Confederated Tribes and Bands  
of the Yakama Nation

Clint Short Plat (SP-08-00054)  
ATTENTION: Allison Kimball  
411 N. Ruby St., Suite 2  
Ellensburg, WA 98926

TO: Phil Rigdon, Deputy Director, DNR  
THROUGH: Scott Nicolai, Yakima Subbasin Habitat Coordinator, YKFP  
FROM: John Marvin, Habitat Biologist, YKFP  
DATE: Thursday, January 22, 2009  
RE: Clint Short Plat (SP-08-00054)

SHORT PLAT NO. _____
KITITAS COUNTY, WASHINGTON

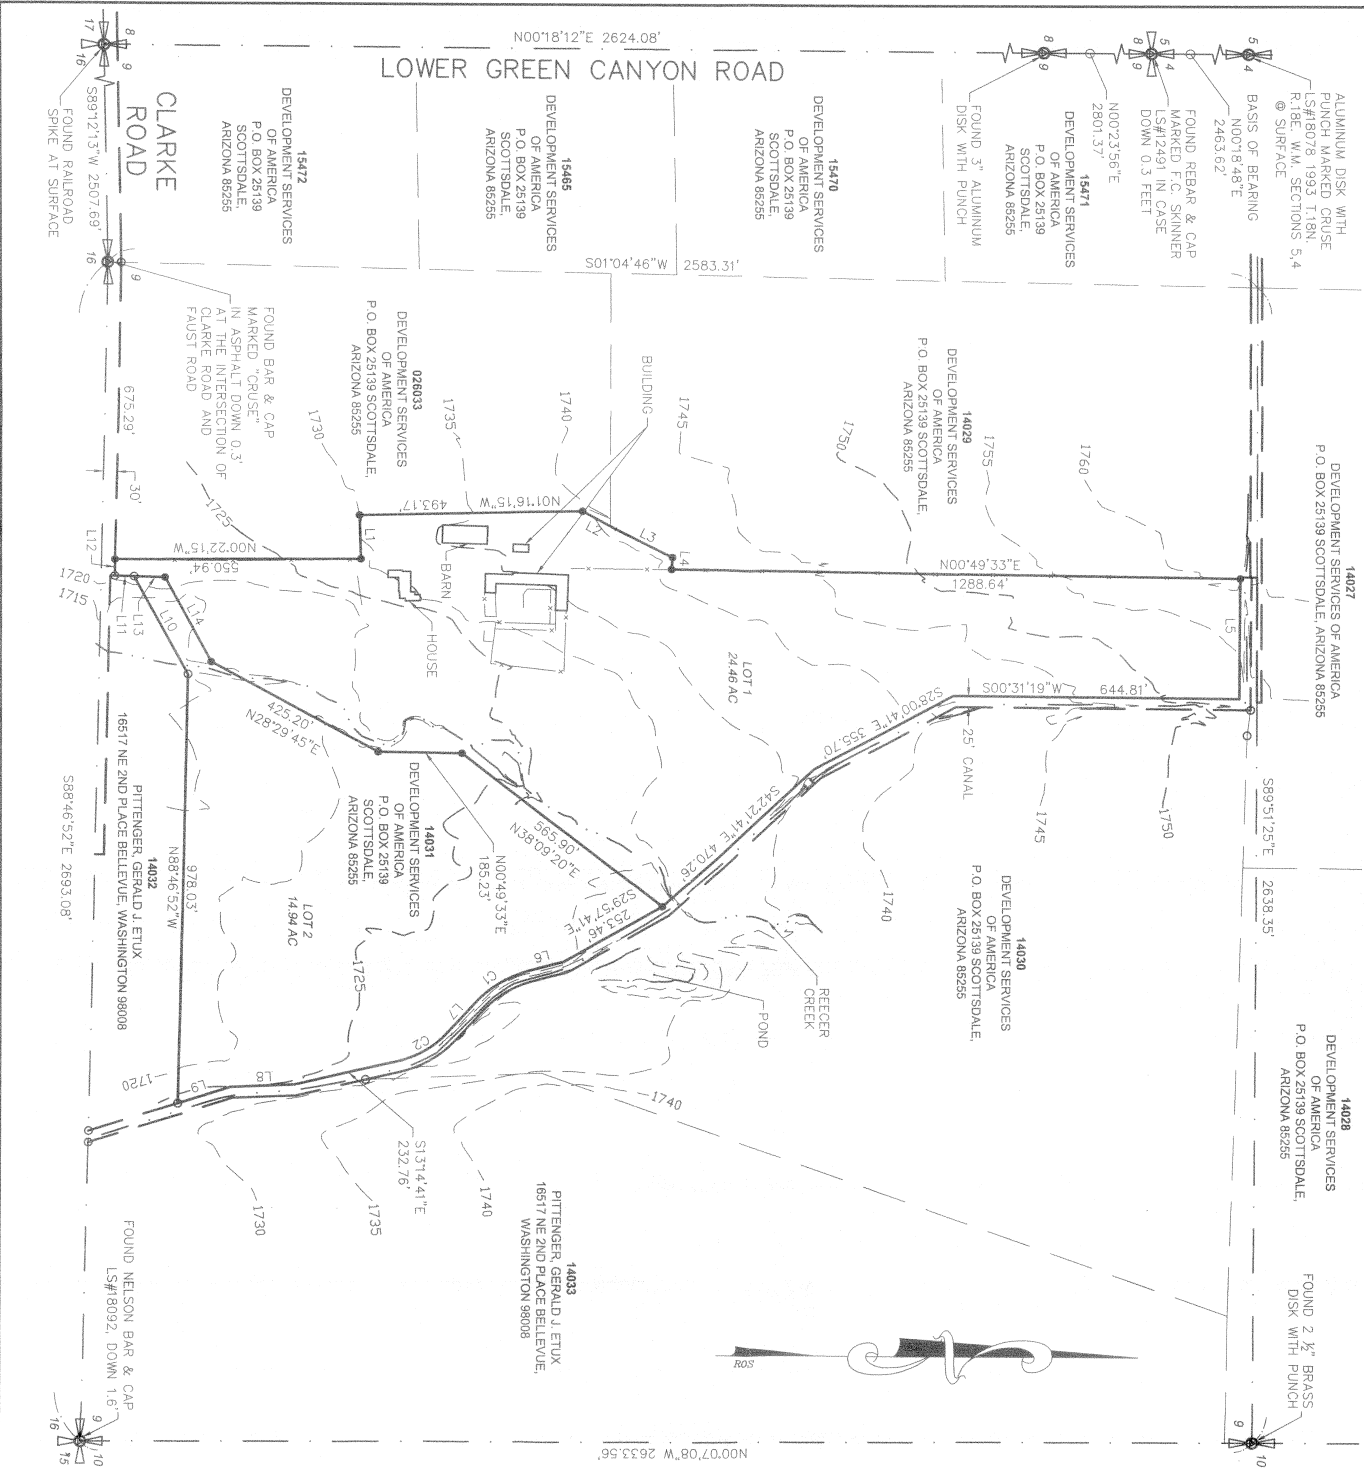
- Reconfigure parcel dimensions to place Reecer Creek on one parcel.
- A boundary line adjustment with parcel 14032, in addition to the proposed short plat could provide access from Clarke Road without the need for a bridge. If

parcel reconfiguration is not required, bridge engineering should be provided to meet FEMA standards.

- A wetland delineation should be provided, and wetland dimensions recorded on the final plat.
